CITY OF ALBUQUERQUE
 PLANNING DEPARTMENT
 DEVELOPMENT REVIEW BOARD

PUBLIC AGENCY COMMENTS

Project# 1007442
 15DRB-70337 – SITE DEVELOPMENT PLAN
 FOR BUILDING PERMIT

FLOYD DEVELOPMENT SERVICES LLC agents for PURVIS INDUSTRIES request the referenced/above action for Tract 7-B-1, **MIDWAY BUSINESS PARK** zoned IP, located on the northeast corner of SINGER BLVD NE and MIDWAY PARK BLVD NE containing approximately 3.16 acre. (E-17 / F-17)

1 SOUTH EXTERIOR ELEVATION
SCALE: 1" = 10'-0"
226'-2 1/2"

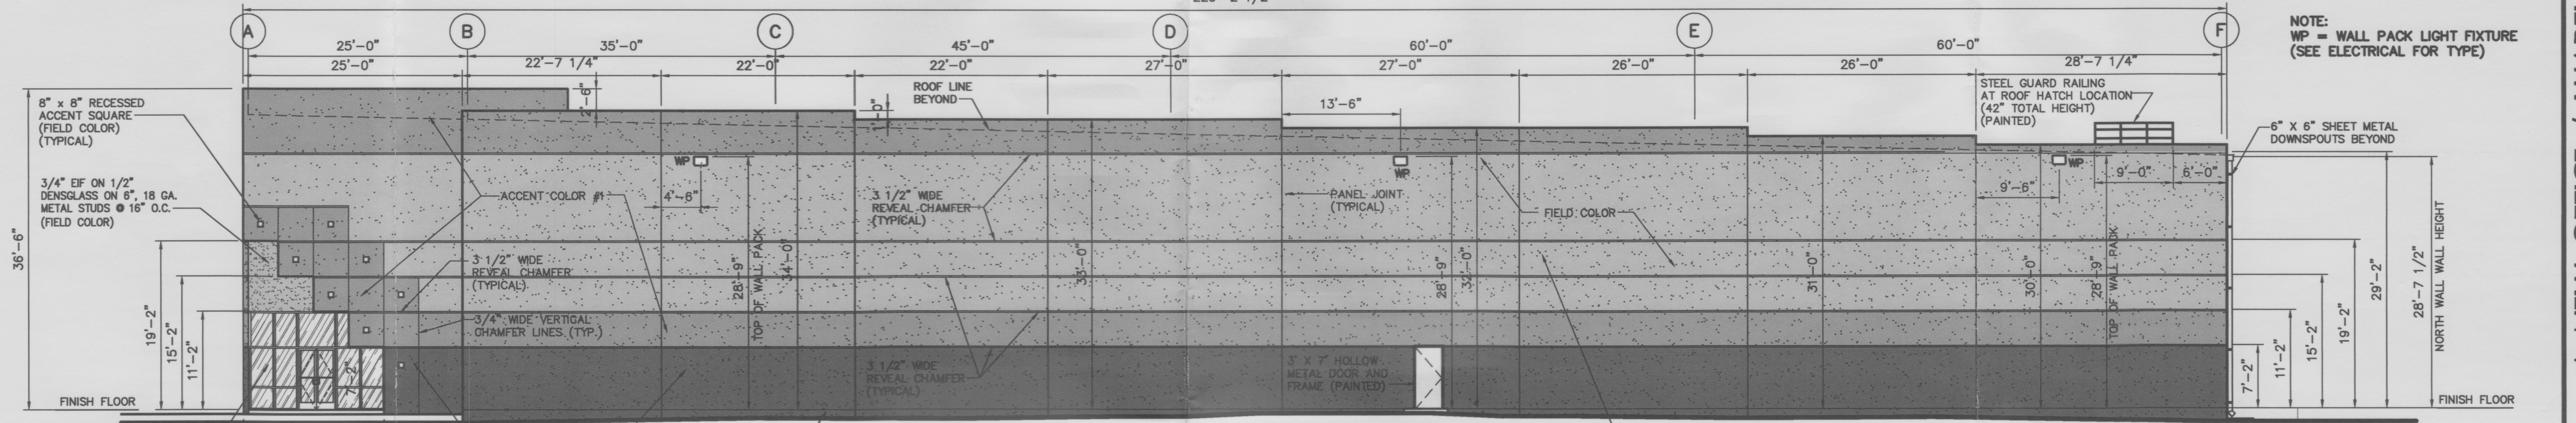
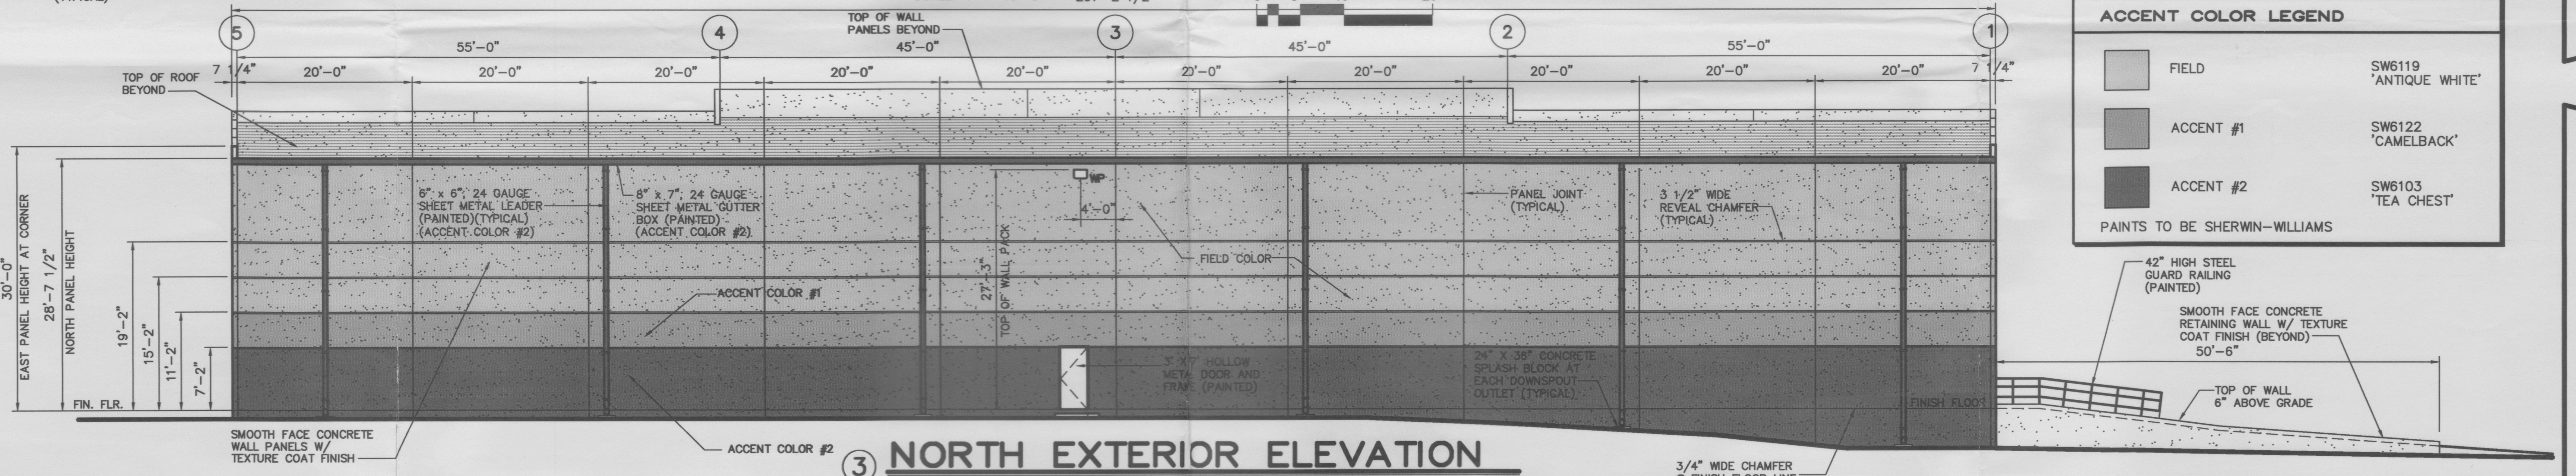
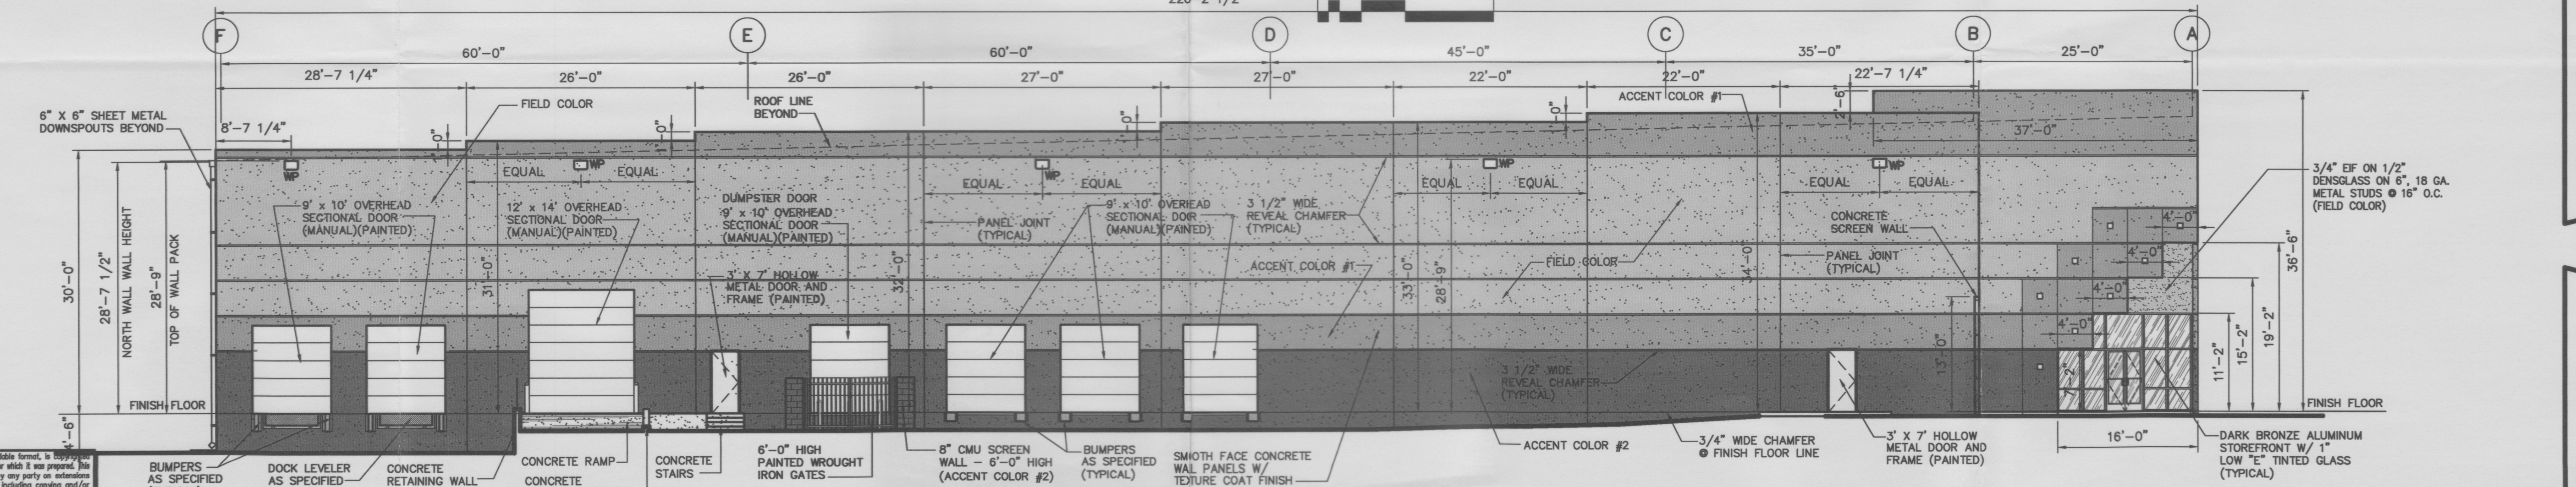
PARKS AND RECREATION <i>Carol Dumont</i> cdumont@cabq.gov	Parks and Recreation has no adverse comments for this request. Information comment only is that the Bikeways and Trails Plan identifies a proposed bike lane on this section of Singer Blvd.
CITY ENGINEER/ HYDROLOGY <i>Rita Harmon</i> RHarmon@cabq.gov	
ABCWUA <i>Kris Cadenda</i> KCadena@abcwua.org	
TRANSPORTATION DEVELOPMENT <i>Racquel Michel</i> RMichel@cabq.gov	
PLANNING DEPARTMENT <i>Jack Cloud</i> jcloud@cabq.gov	Refer to comments from Zoning Enforcement plus any public hearing comments regarding proposed site plan. The building does not appear to meet the height requirements of the IP zone on the north and south elevations.

LANDSCAPE PLAN

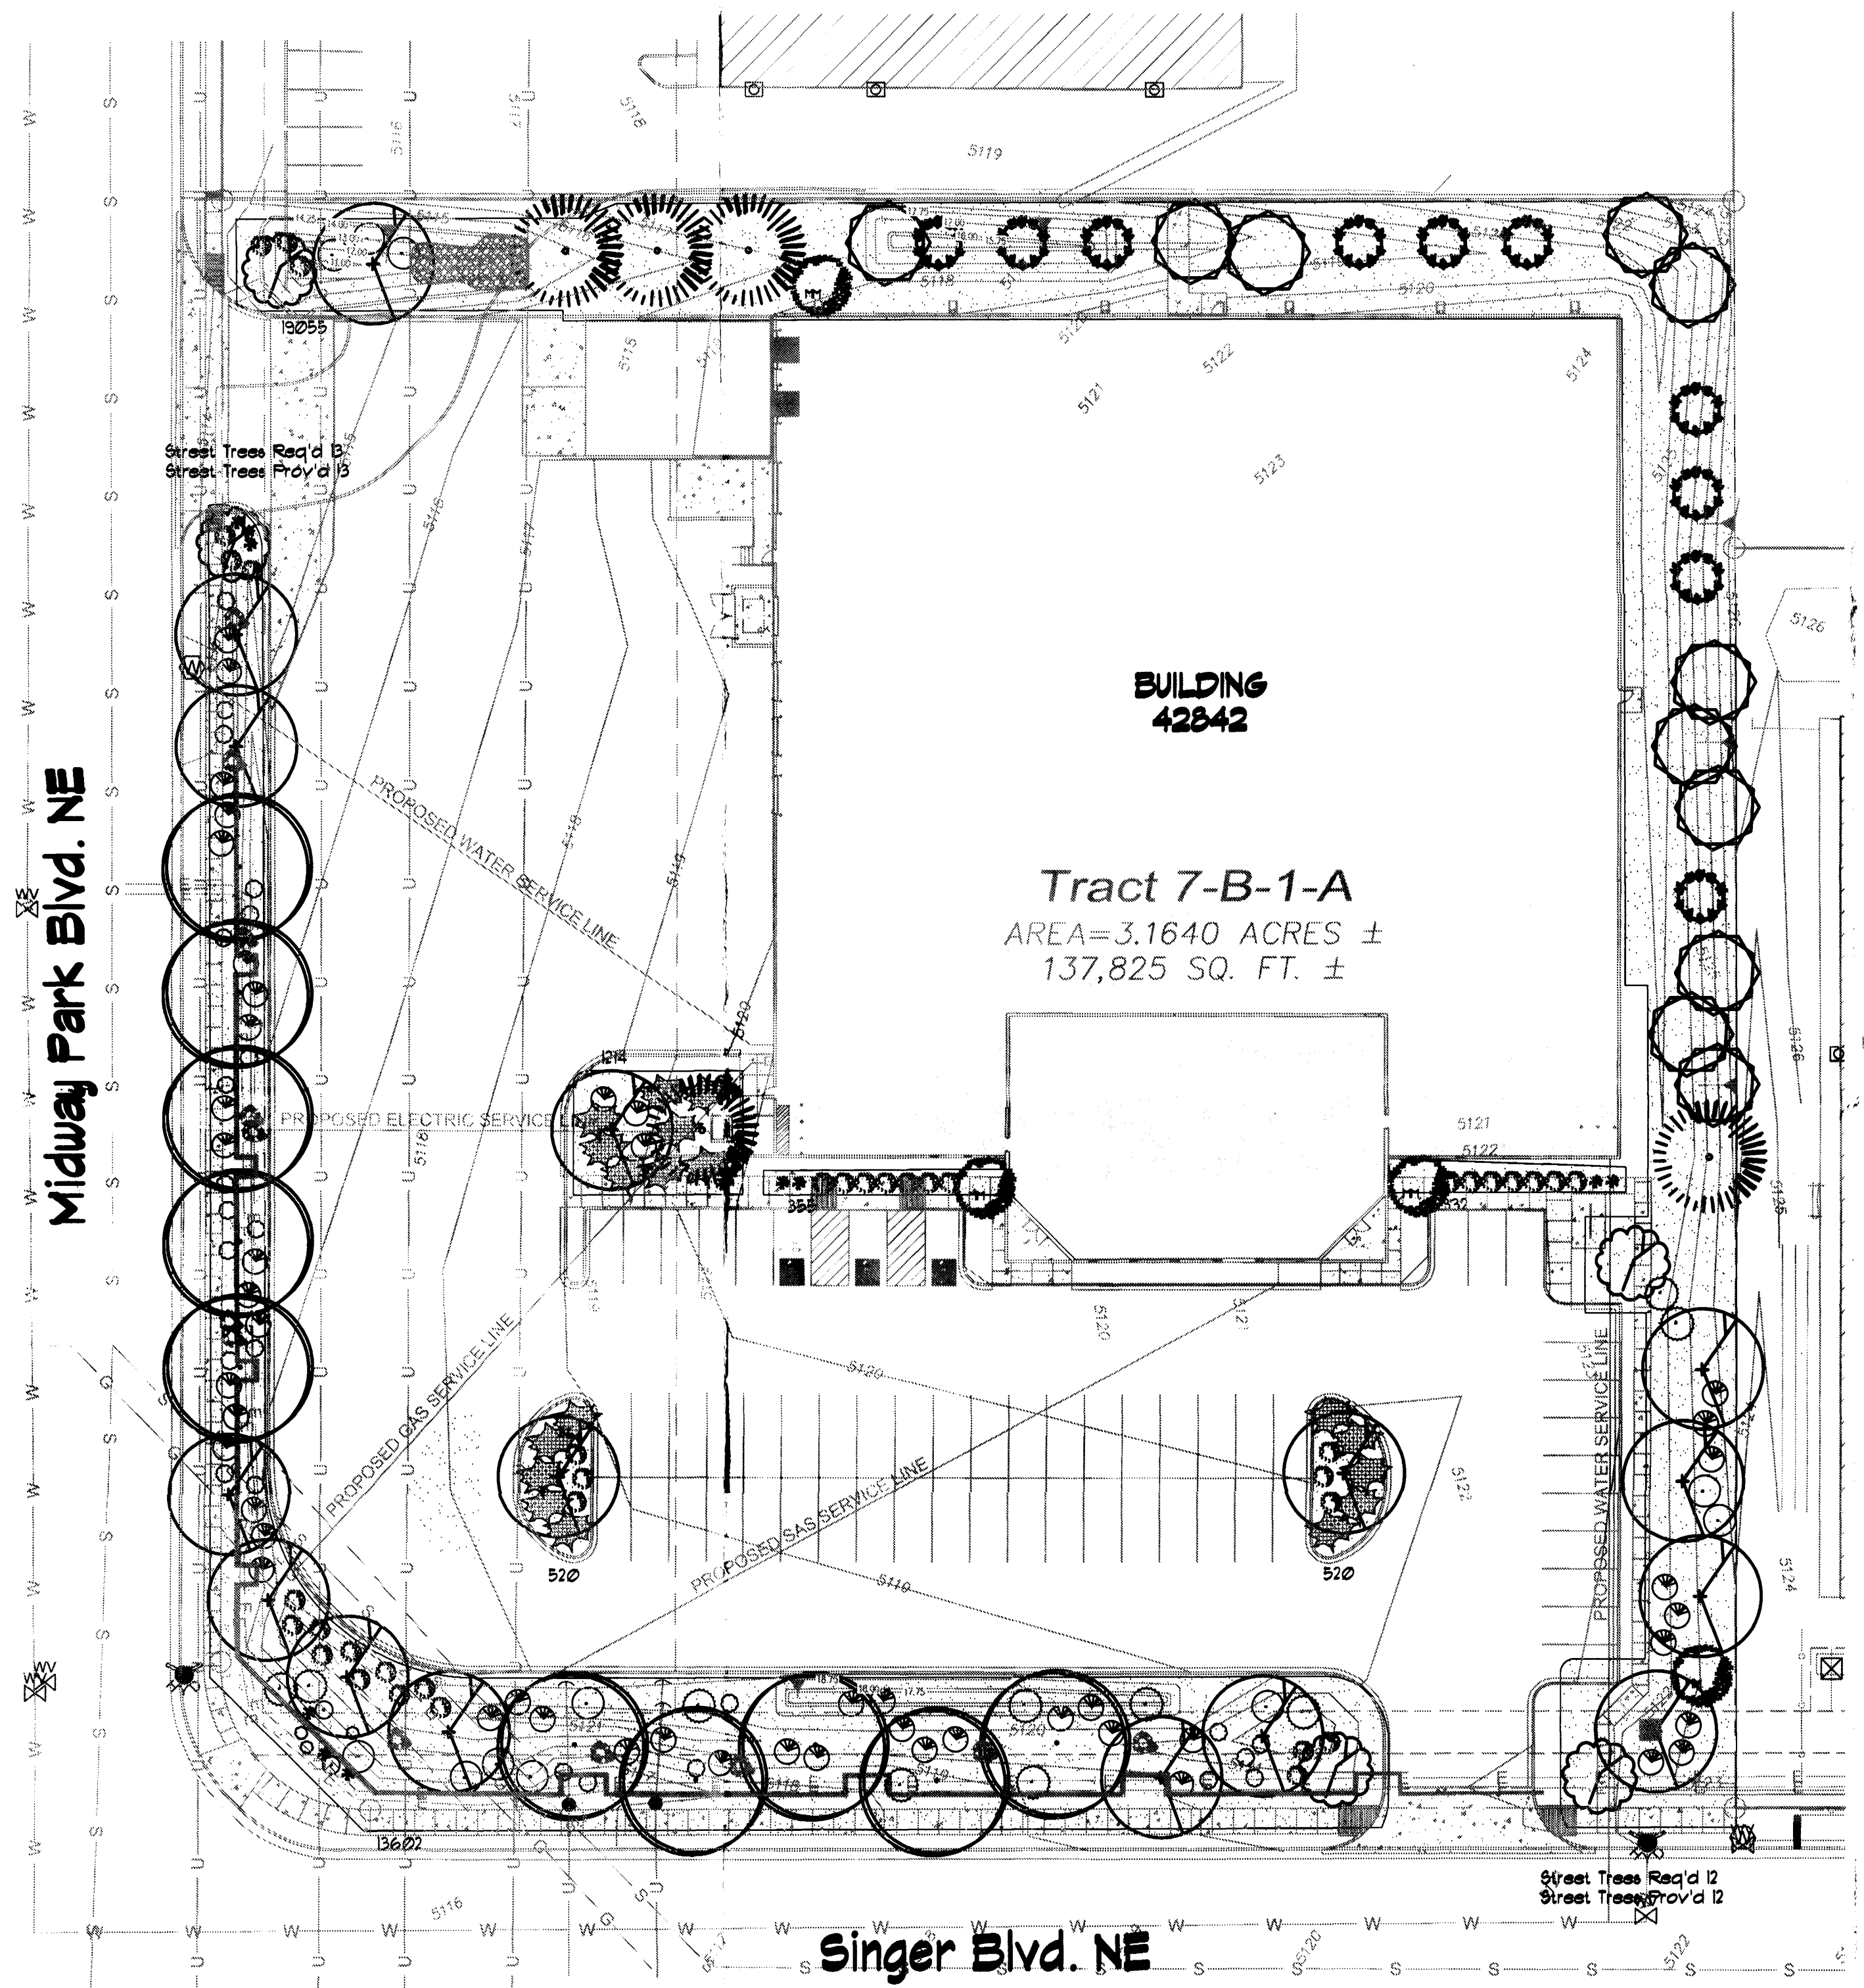
<p>POLICE DEPARTMENT <i>Steve Sink</i> SSink@cabq.gov</p>	<p>... project is in the Valley Area Commar</p> <ul style="list-style-type: none"> - It appears proposed exterior lighting is in conflict with proposed landscaping. Recommend removing from the plans large tree-variety landscaping in areas immediately adjacent to parking lot pole lights. Once trees become mature, they will reduce the effectiveness of available illumination. Additionally, all low-level bush variety landscaping should be maintained to a height no higher than three feet. All building approaches should also be void on landscaping to provide as much natural surveillance as possible. - Suggest incorporating into the plans a video surveillance systems. Cameras should be positioned to view all vehicle/pedestrian access points, parking lots, walkways, building approaches, common areas and maintenance facilities. Each camera should be monitored and recorded for real-time and historical use.
